The Drovers Solar Farm

Appendix 9.1: Consultation and Legislation, Planning Policy and Guidance

Document reference: APP/6.4 (Original)

DWG. NO. Figure 9-1

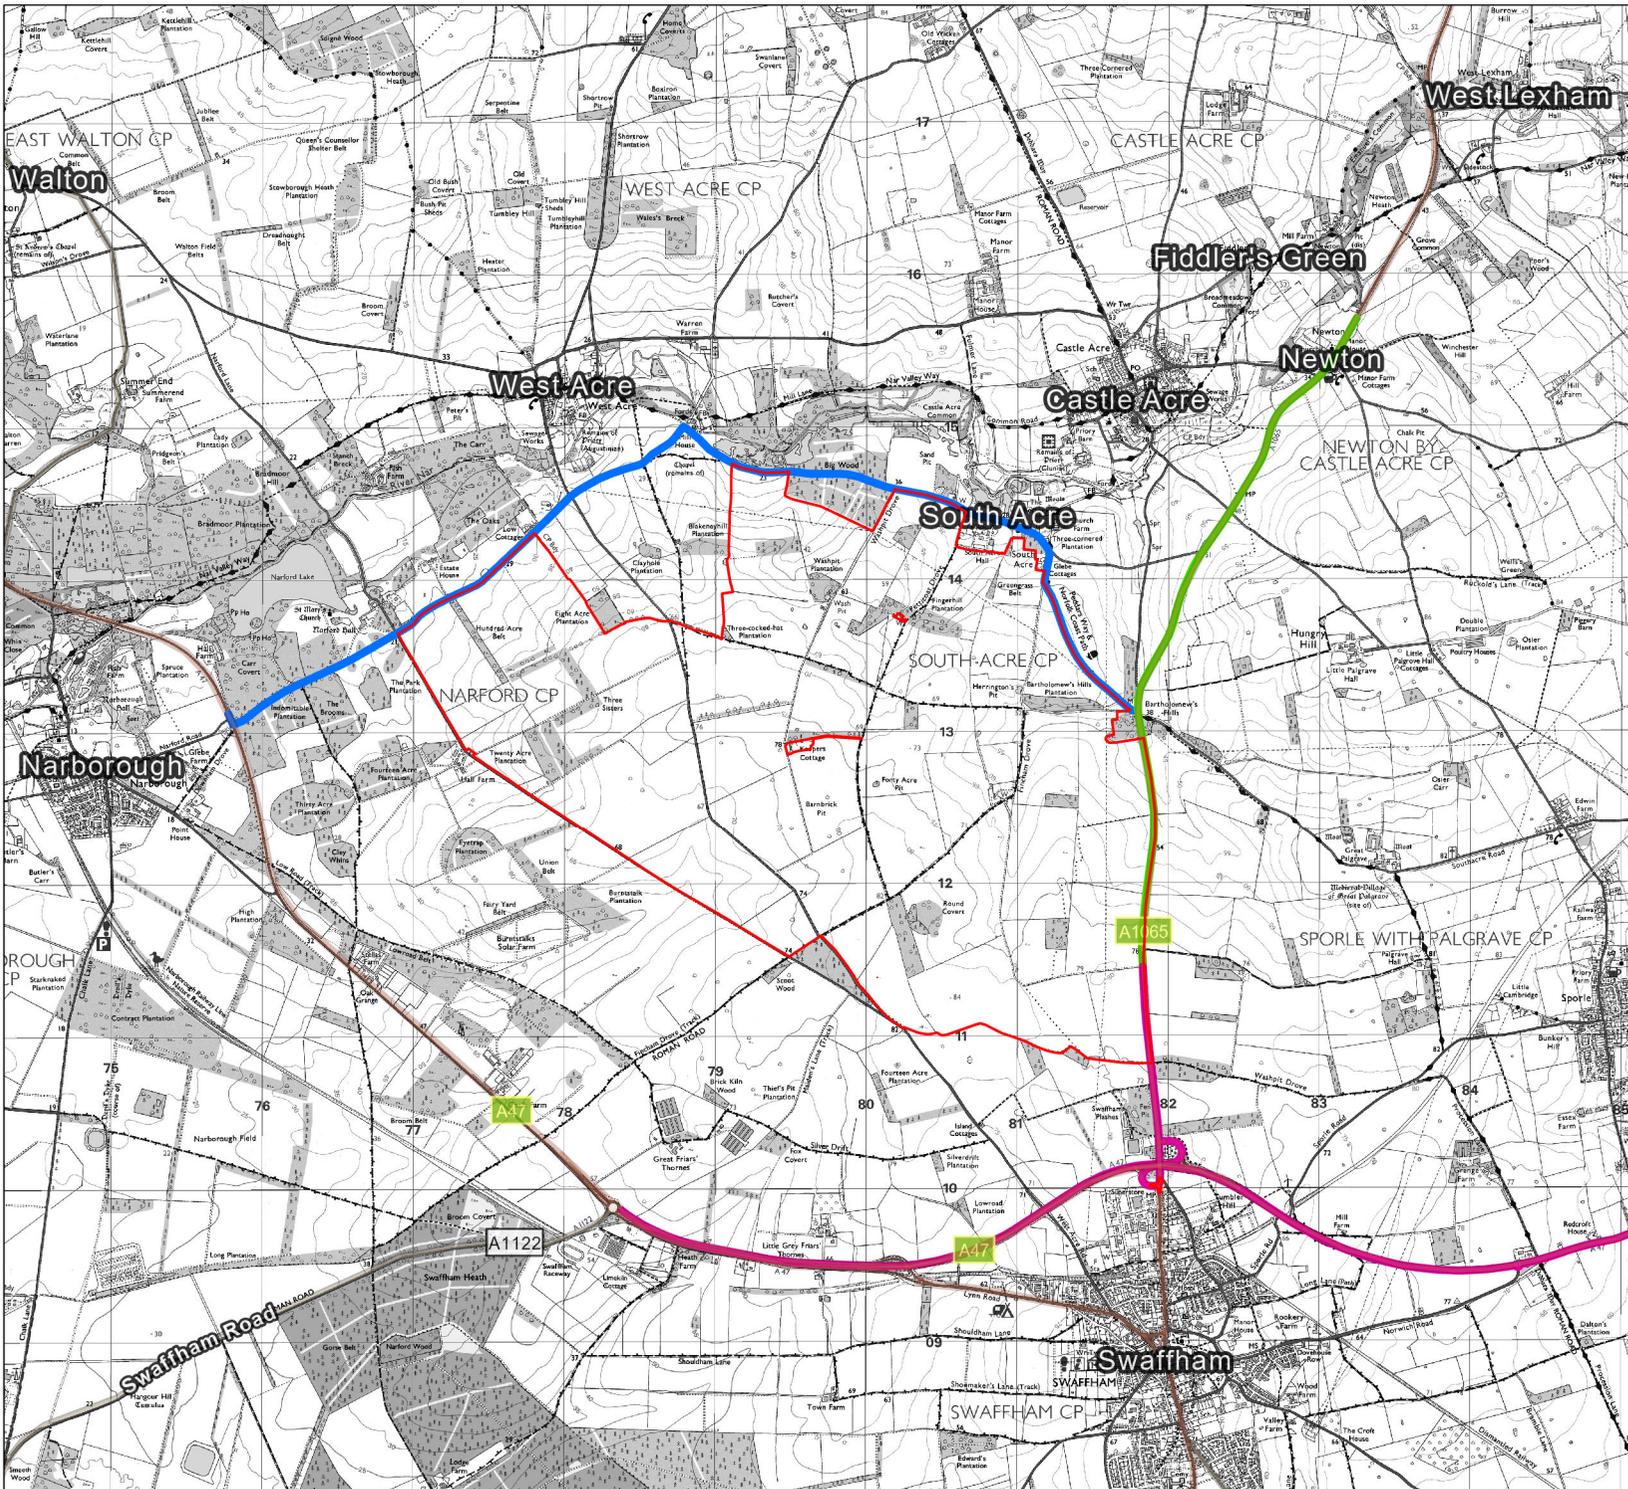
| Norfolk County Council (NCC), May to July 2025 Statutory Consultation | Figure 9.1 construction Vehicle Routing and Constraints – No HGVs to use link 3 on drawing. | The Applicant confirms as part of the construction phase of the Scheme that HGVs will not use Link 3 (via Narford Road) to the west. | The routing for construction vehicles as part of the construction phase is secured through the oCTMP |

| period for responses to PEIR | | | [APP/7.7] and via the DCO Application. |
